Date: 13 January 2025
Our ref: 496522
Your ref: EN010140

Title: Natural England's Written Representations in respect of Helios Renewable Energy Project (EN010140), promoted by Enso Green Holdings D Limited.

Examining Authority's submission Deadline 2 with a date of 13 January 2025.

## **Environmental Statement Figure 3.14: Construction Vehicle Route**

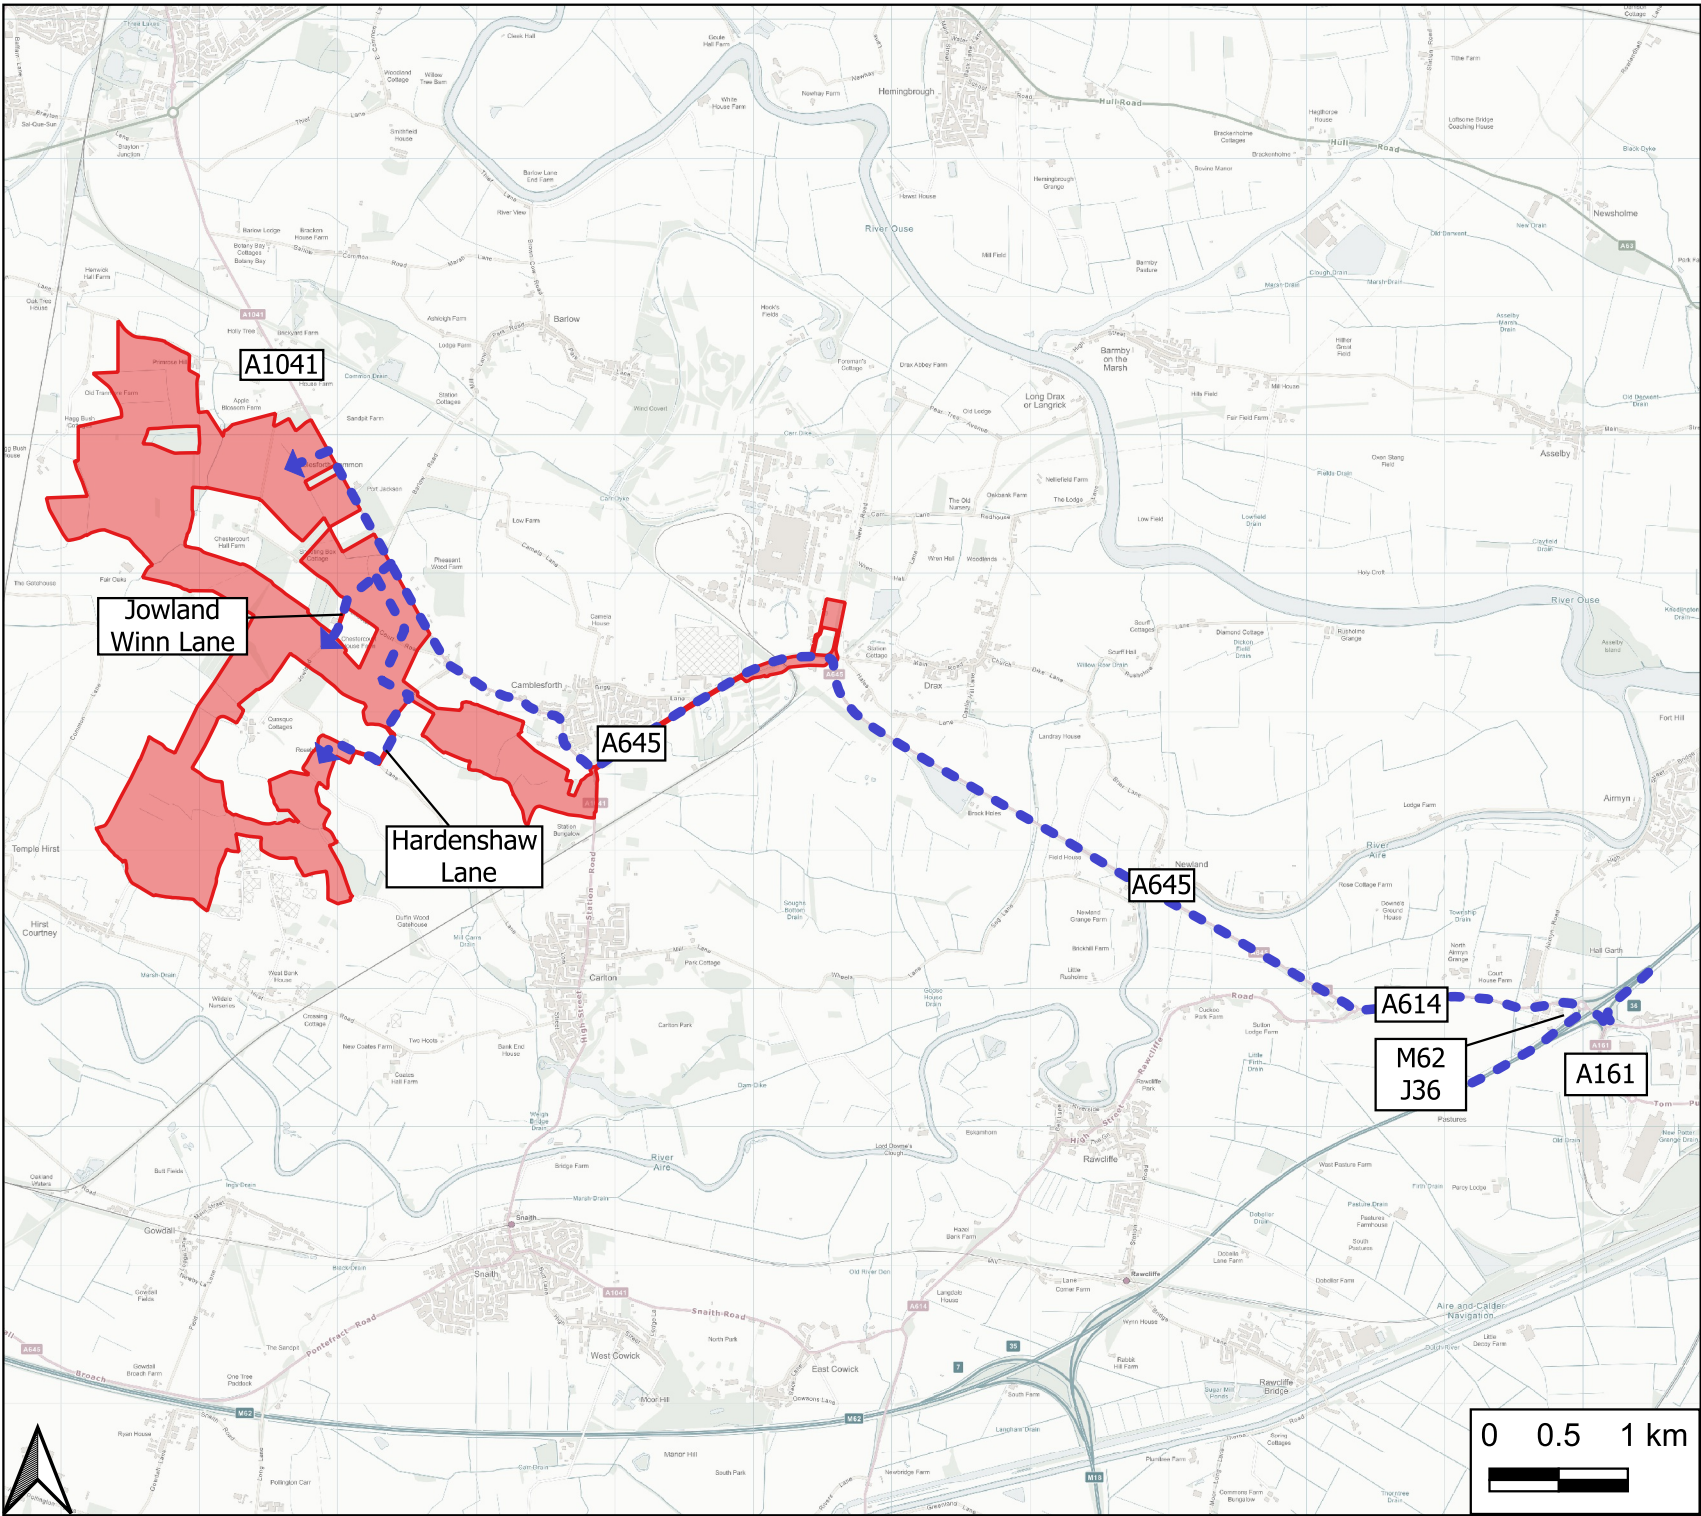
- **Internationally designated sites**
 - Potential loss of functionally linked land (FLL) for SPA / Ramsar birds.
 - Potential noise disturbance during construction to FLL for SPA / Ramsar birds.
 - Operational impacts to FLL for SPA / Ramsar birds.
 - Potential air quality impacts from construction traffic.
 - In-combination impacts.

- **Nationally designated sites**
 - Overlapping internationally designated site impacts for the relevant SSSIs.
 - Potential air quality impacts from construction traffic.

- Potential air quality impacts from construction traffic on nationally designated sites (construction) ('amber') **[NE10]**
- Potential impacts on the interest features of Eskamhorn Meadows SSSI ('amber') **[NE13]**

NE10	Nationally designated sites All relevant nationally designated sites	Potential air quality impacts from construction traffic on nationally designated sites. (C)	We note the Applicant's position in REP1-004, and PDA-004 (NE-10), that the air quality assessment information will be provided at a future deadline. We will advise further after submission of this information.	N/a: Further information required.	'Amber'
NE11	Nationally designated sites Humber Estuary SSSI	Impacts on the interest features of the Humber Estuary SSSI	As stated in RR-068, our advice regarding Humber Estuary SSSI broadly coincides with advice set out above for Humber Estuary SPA/Ramsar. We noted however that the SSSI is designated for additional features, and that potential impacts on these features should also be considered in the relevant assessment and appropriate justification provided where impacts are ruled out. We note that the Applicant states in NE-11 of REP1-004 and PDA-004 that further consideration will be provided, however, this states that this will be for the SPA/Ramsar site and not the SSSI. We would advise clarification is provided around whether the features of the SSSI are due to be assessed also.	N/a: Further Information Required	'Amber'
